STATE OF NORTH CAROLINA
DEPARTMENT OF TRANSPORTATION

Addendum No. 1

RE: Contract ID: C202679
WBS # 1C.037030, etc.
Gates County
2 Sections of US-158, 1 Section of US-13 and NC-37 and 10 Sections of
Secondary Roads

January 18, 2011 Letting

PROJECT REFERENCE NO.	SHEET NO.
1CR.10371.11, ETC.	7

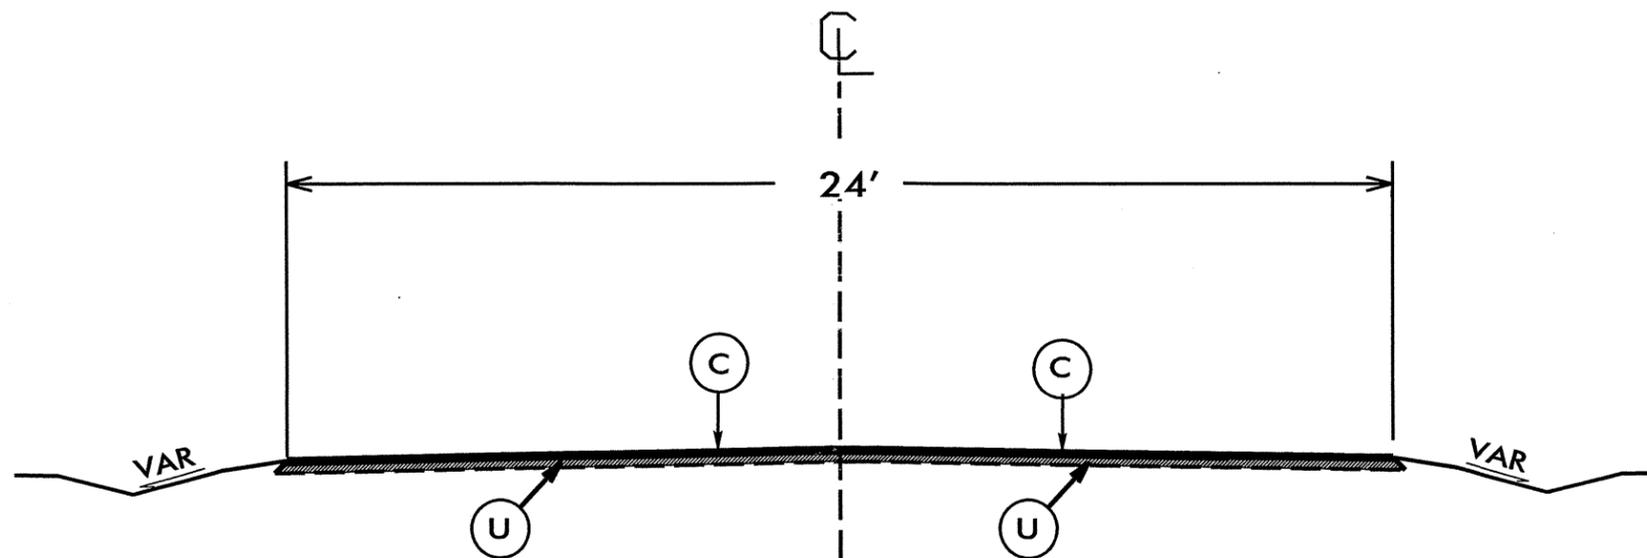
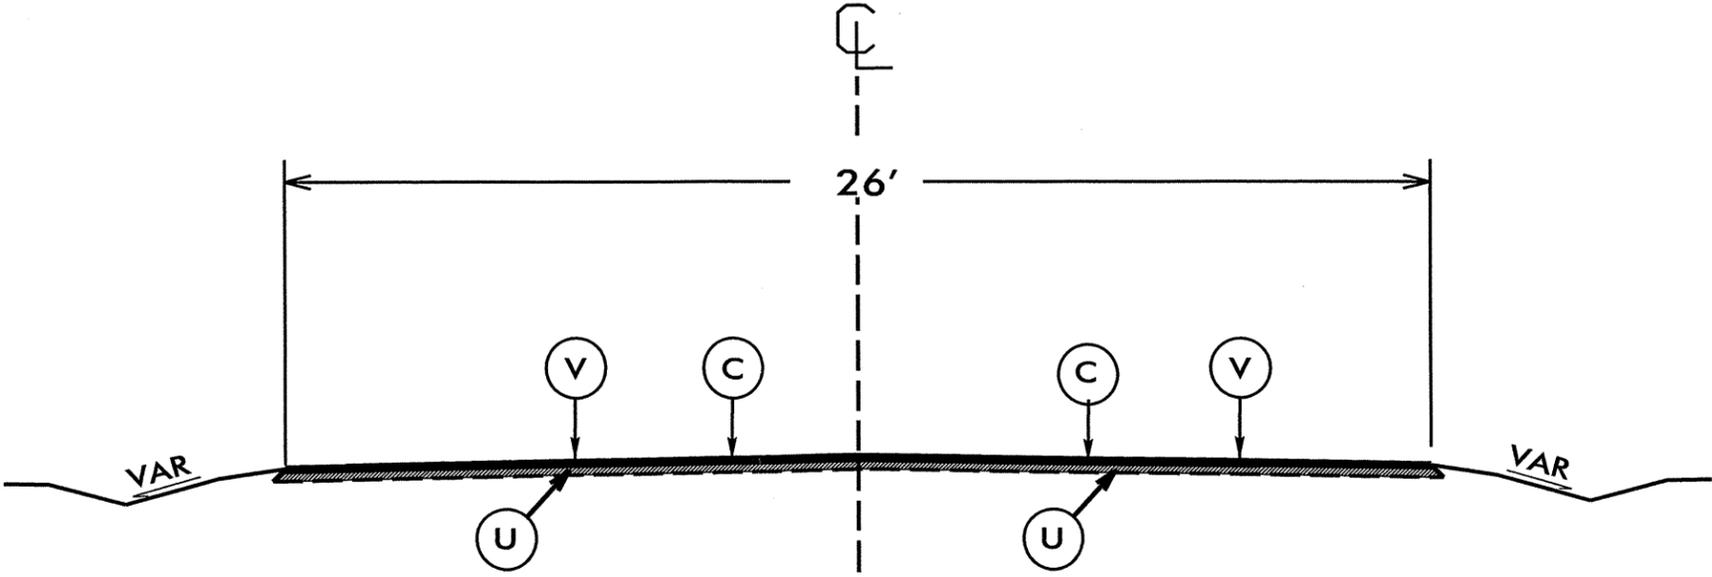
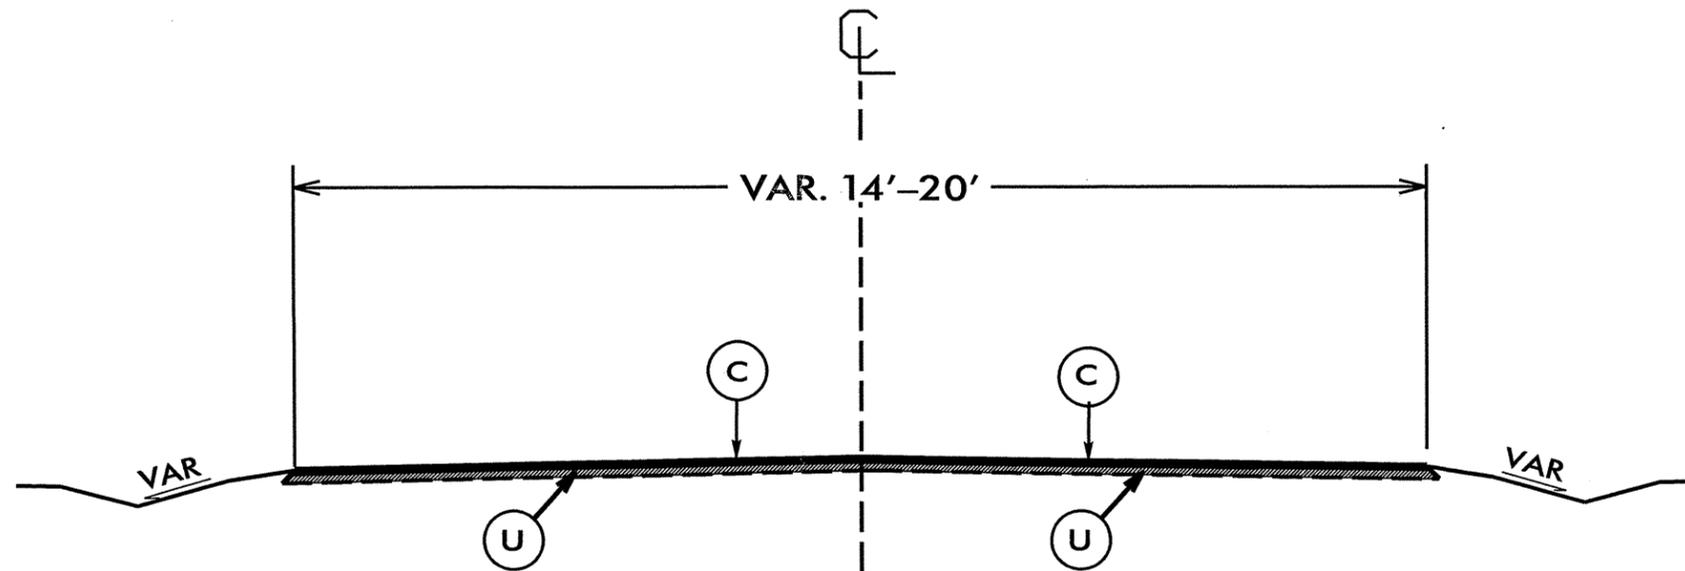
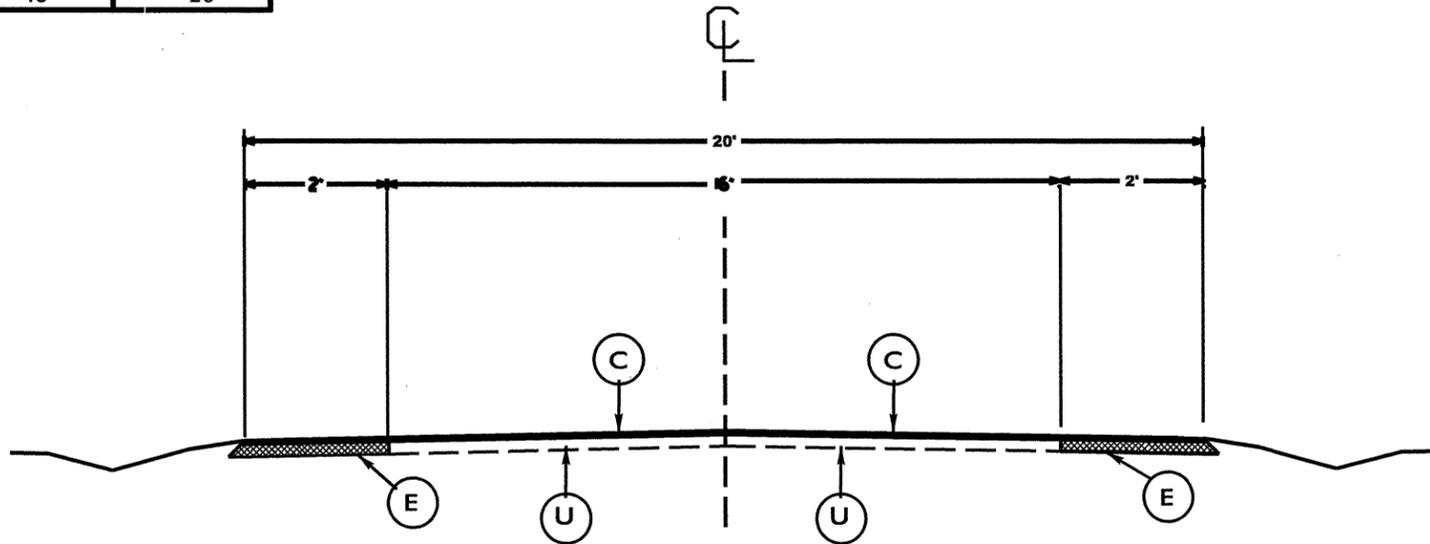
Sheet No. 7 has been revised to correct the pavement schedule. Please void Sheet No. 7 in your plans and staple the revised Sheet No. 7 thereto.

Sht. no. 8

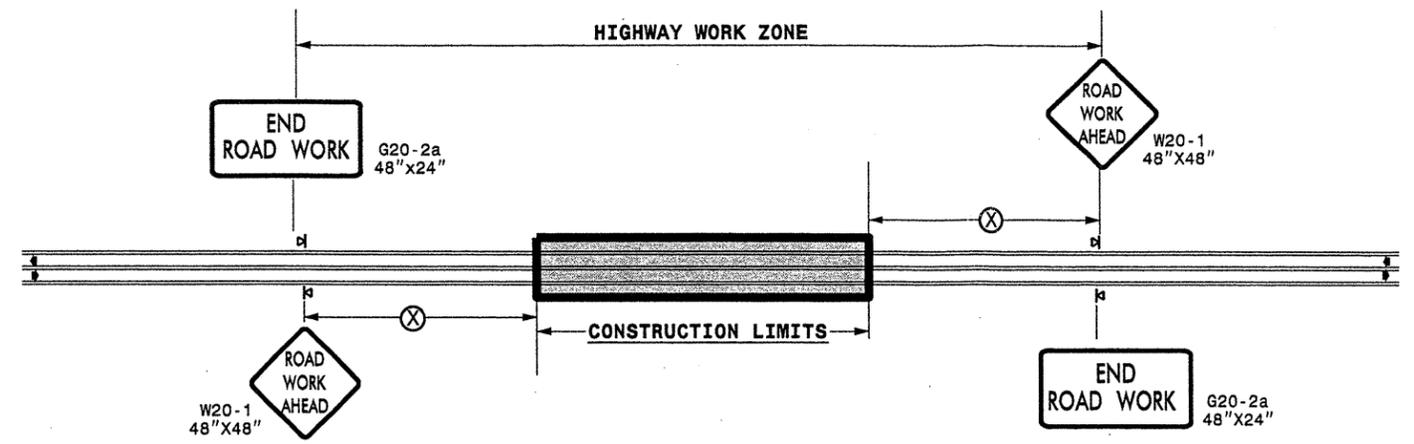
Sheet No. 8 (Summary of Quantities) has been revised to include Incidental Milling. Please void Sheet No. 8 in your plans and staple the revised Sheet No. 8 thereto.

<u>Item</u>	<u>Description</u>	<u>Old Quantity</u>	<u>New Quantity</u>
5-1297000000-E-607	Milling Asphalt Pavement, 1-1/2" Depth	8,593 SY	8,448 SY
21-1891000000-E-SP	Incidental Milling	NEW ITEM	145 SY
